Application No: WA/18/26/PL
Site Address: Land off Arundel Road Fontwell
Description of works: Erection of 64 residential dwellings with access off Arundel Road, together with associated parking, open space, play space, landscaping, drainage and infrastructure. This application is a Departure from the Development Plan, affects a Public Right of Way, may affect the setting of listed buildings and is in CIL Zone 3 and is CIL Liable as new dwellings.

Thank you for your internet representation made on 30th March 2026 which has been recorded as an objection with the comments as follows:

Further to my original objection, I wish to raise the following additional material considerations and formally request further assessment before any determination is made.

Dwg. 33186-D-01 Rev. P1 land North of Arundel Road, Fontwell, Proposed Access

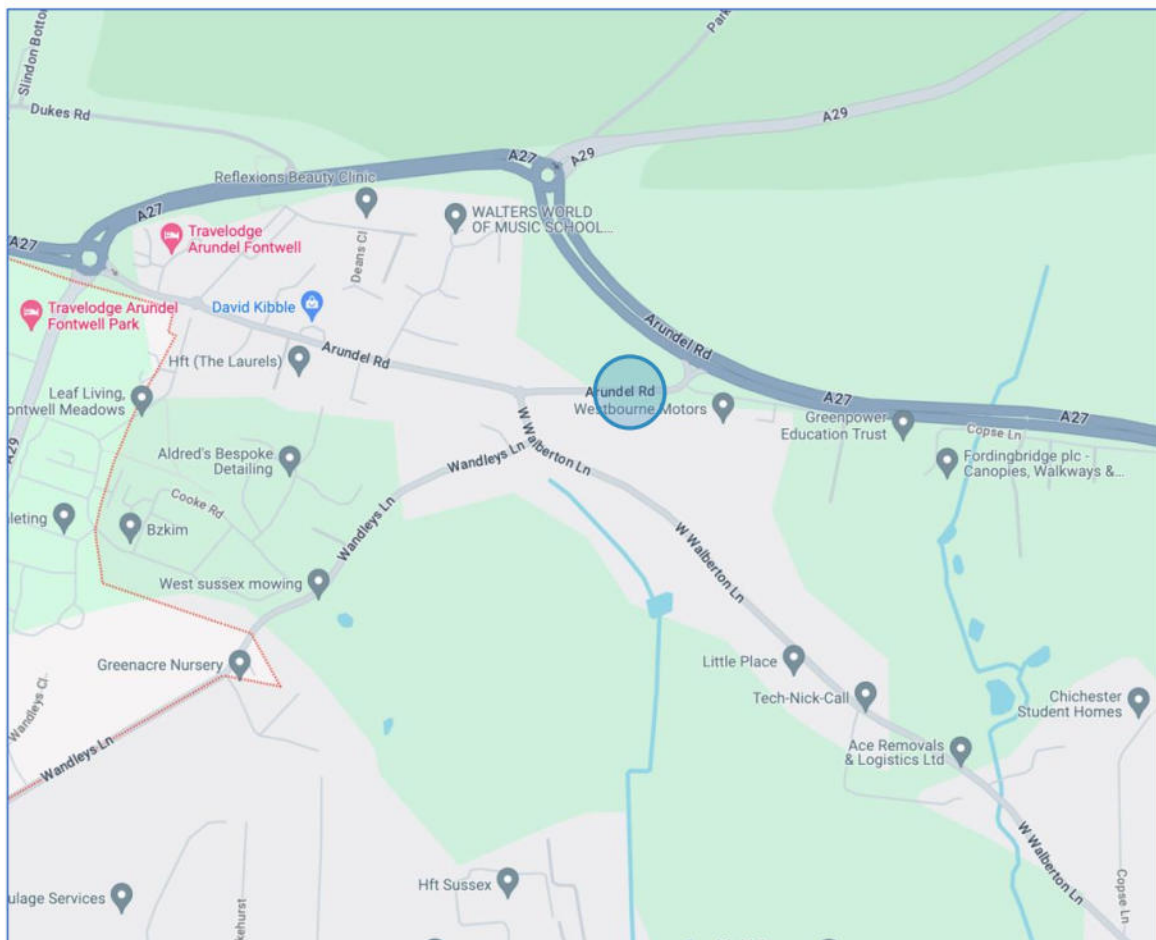
While the submitted drawings show the position of my dwelling, they fail to show my existing driveway, which is located directly opposite the proposed site access.

This is a significant omission. As a result:

- The plans are inaccurate
 - The Transport Assessment is based on incomplete information
 - The Highway Authority cannot have properly assessed the real-world operation and safety of this junction
- This issue was raised previously but remains unaddressed.

The existing road width appears insufficient to safely accommodate:

- Two-way traffic flow
- Turning movements into and out of the development
- Simultaneous use of the opposing private driveway

This will lead to vehicles slowing or stopping within the carriageway, increasing conflict points and the likelihood of unsafe manoeuvres.

- Accurate, updated plans clearly showing all existing access points, including my driveway
- A speed survey at this exact location to establish actual vehicle speeds
- Visibility splay analysis based on measured speeds and real on-site conditions
- Swept path analysis demonstrating safe turning movements into and out of the site
- Junction capacity and safety assessment that includes the interaction with the opposing driveway
